About the application

Application number: 2023/93797	
What is the application for?:	Erection of extensions and alterations to former club to form 6 apartments
Address of the site or building:	Former Liberal Club, 14, New Road, Kirkheaton, Huddersfield, HD5 0HP
Postcode:	WF14 8PZ

North Elevation - 1:100

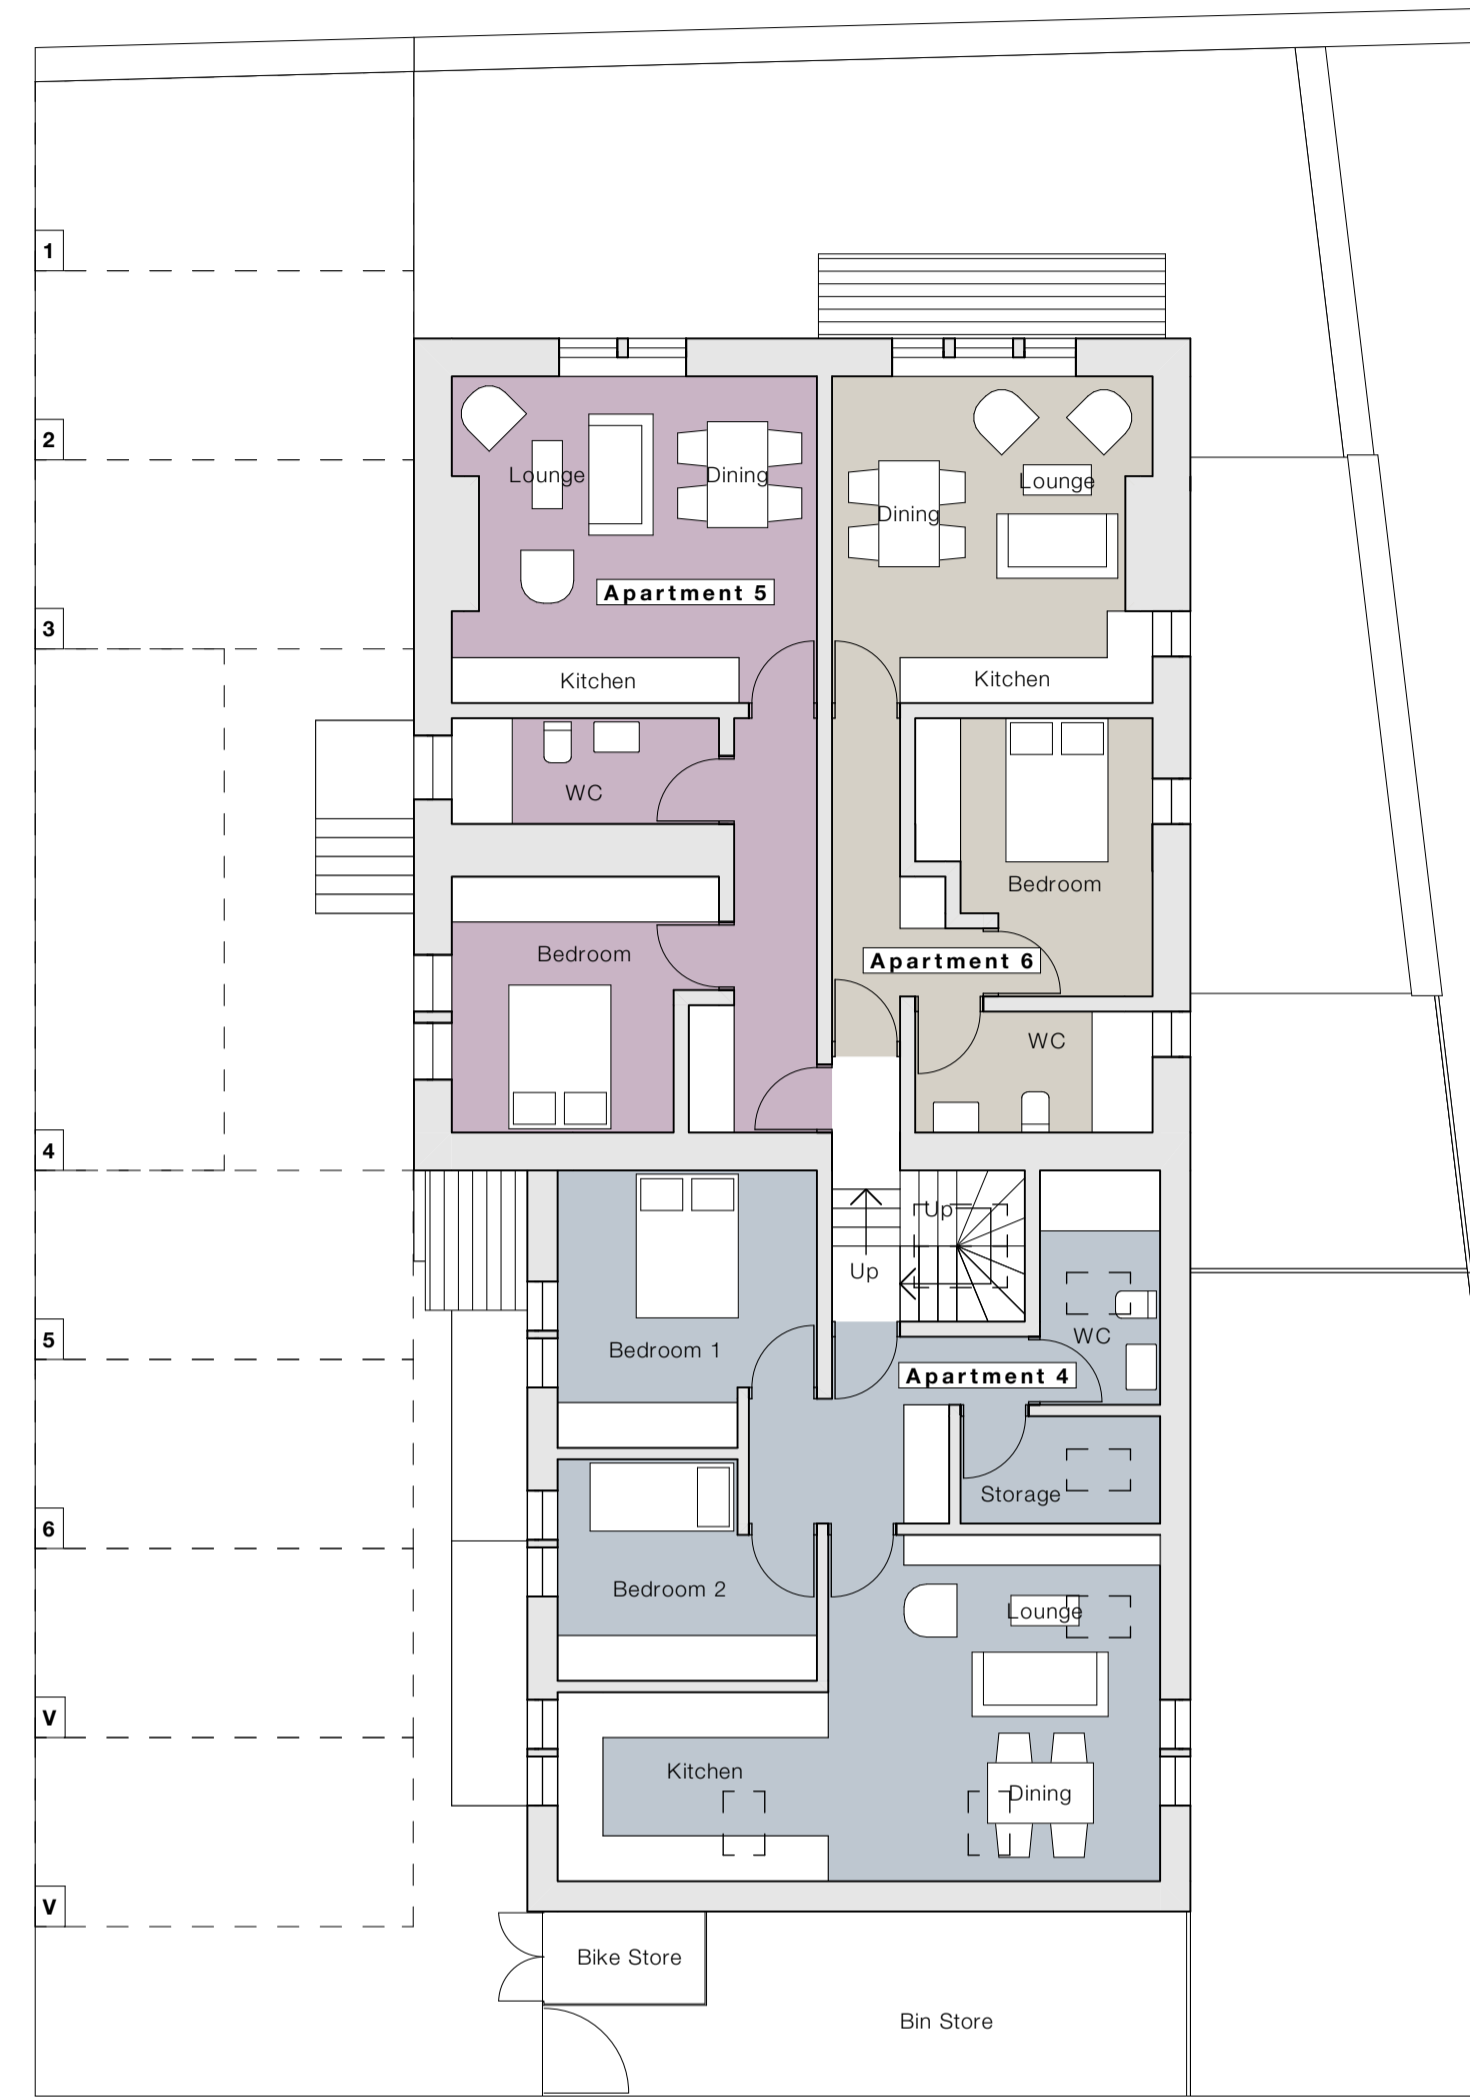
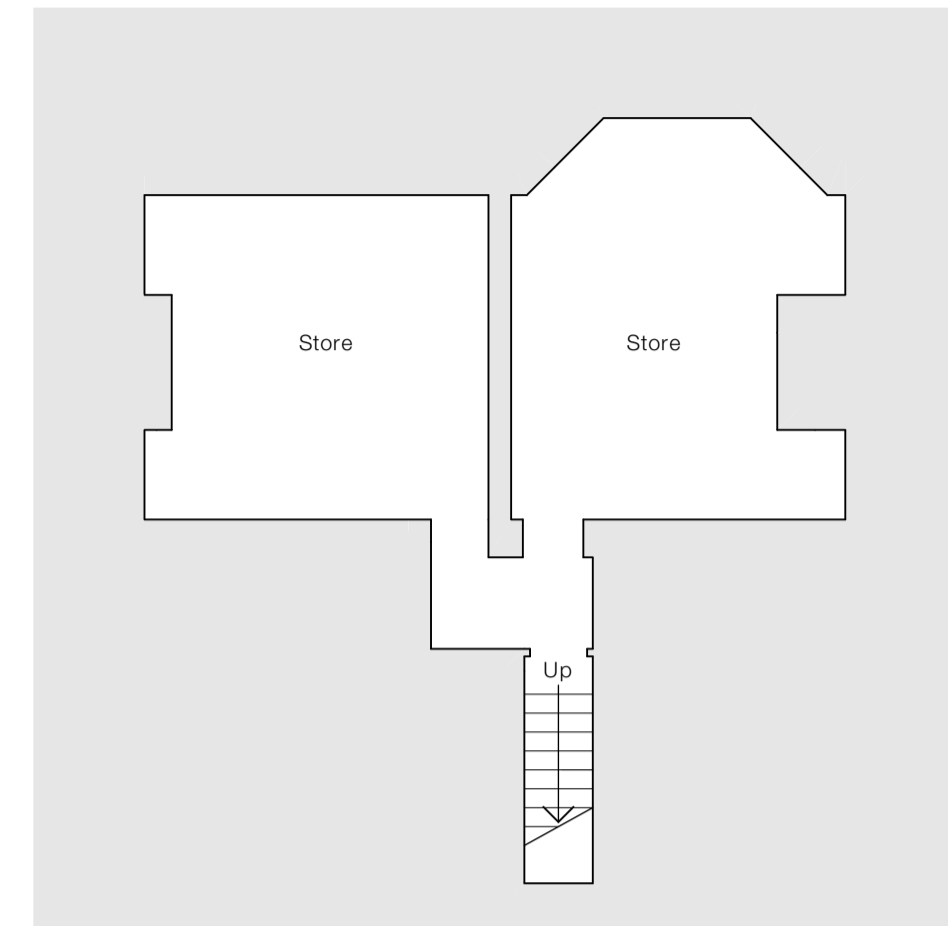
Type of comment: An objection	
Do you wish your comments to be published on the website anonymously?	Yes
The north facing 1st floor windows over looking my property. I have never been overlooked previously. Also how high will the fence be adjacent to my property. There is potential for the occupiers to have 12 cars. Is there ample parking?
